**WEST SUSSEX COUNTY COUNCIL
COUNTY HIGHWAYS CONSULTATION RESPONSE**

DATE: 05/03/2018

SUBJECT: LY/28/17/PL - Change of use of existing building from farm shop & cafe to a brewery tap room (bar), fresh coffee bar & cafe & retail space.

Crossbush Farm Shop, Lyminster Road, Lyminster, West Sussex, BN17 7QN

Block Plan

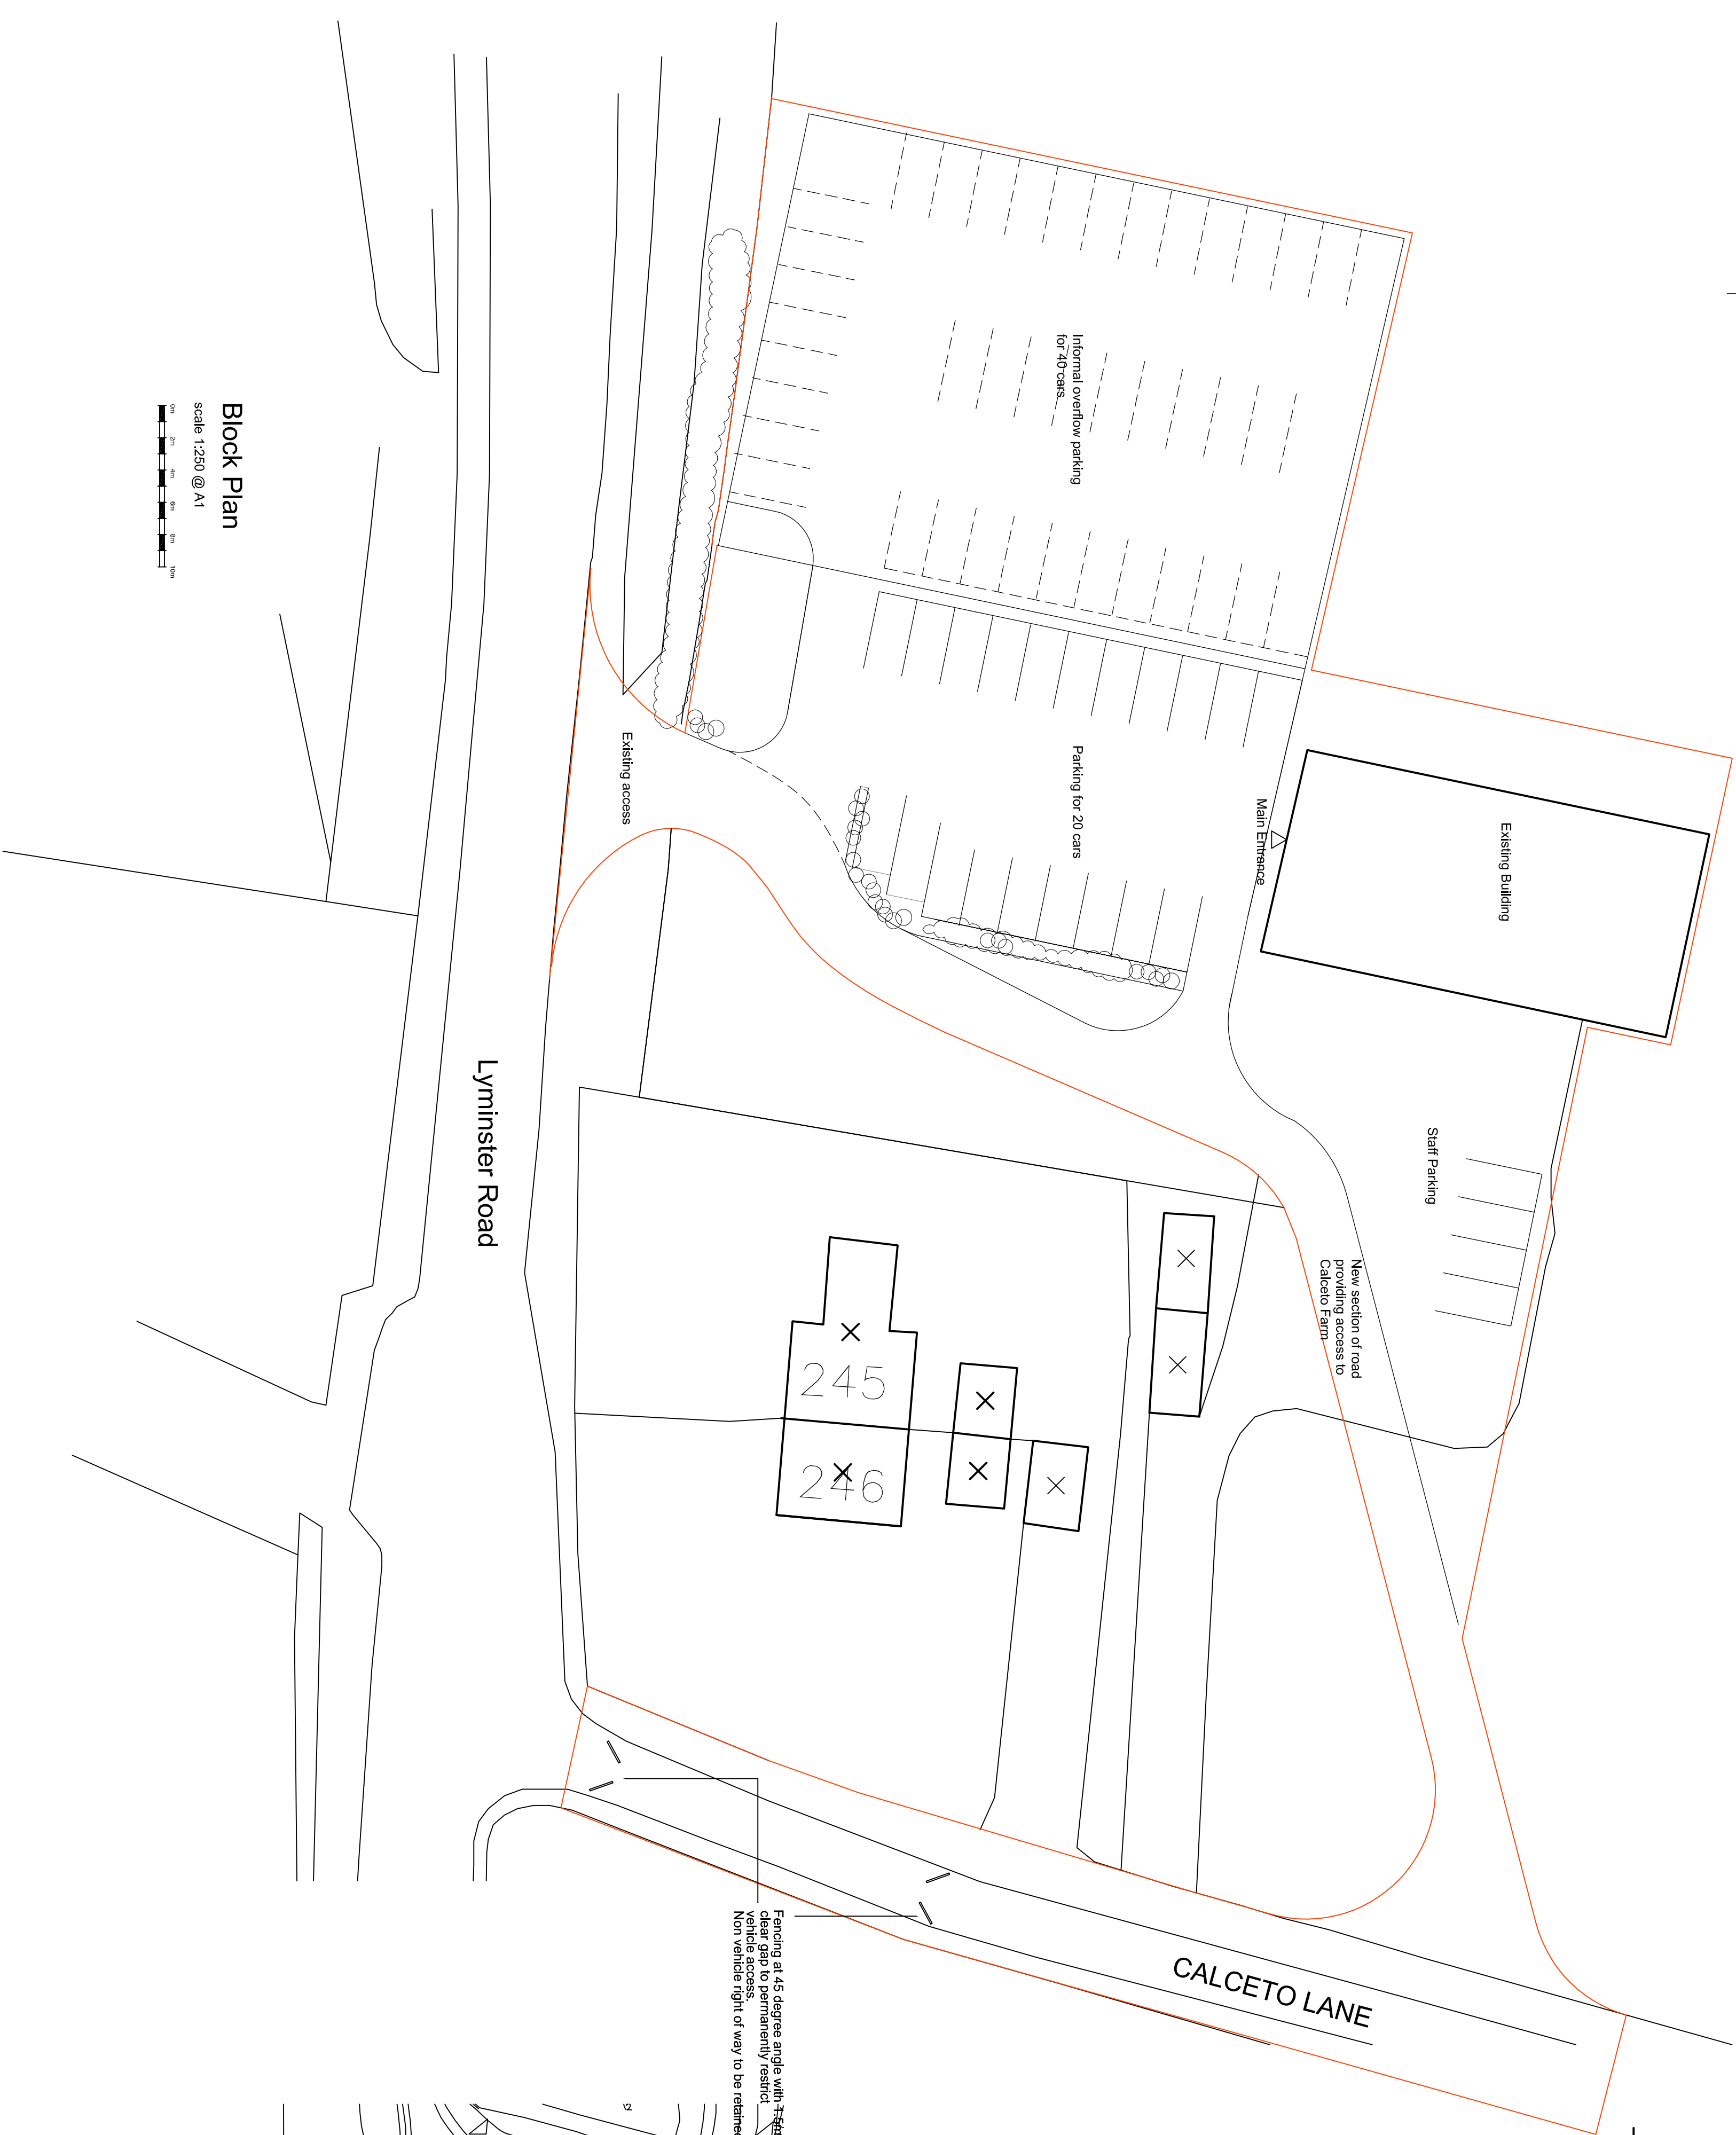
The latest block plan does not show the access closure works on Calceto Lane to remove access by motor vehicles, as approved under LY/14/11. Have these works been implemented? Is this proposed as part of this application?

The plans do not show any improvement works to the main access point onto Lyminster Road which were previously approved under LY/14/11.

The applicant should clarify if these works are to be included (and therefore secured) as part of this planning application, if so plan and details demonstrating them should be submitted.

18 car parking spaces will be retained to serve the proposed use.

For the bar/tap room/cafe WSCC would anticipate a maximum parking requirement of 1 space per 5 sqm of public area and 2 spaces per bar (or 5m length of bar for large bars) for staff. Staff parking should be clearly designated.

Based upon the details provided to date this would equate to a maximum parking demand of circa 60 car parking spaces. It should be noted that the parking demand for A1 use class is less intensive than that for A3 use outside the defined town centre.

The applicant should provide additional details to justify this significant shortfall in car parking provision.
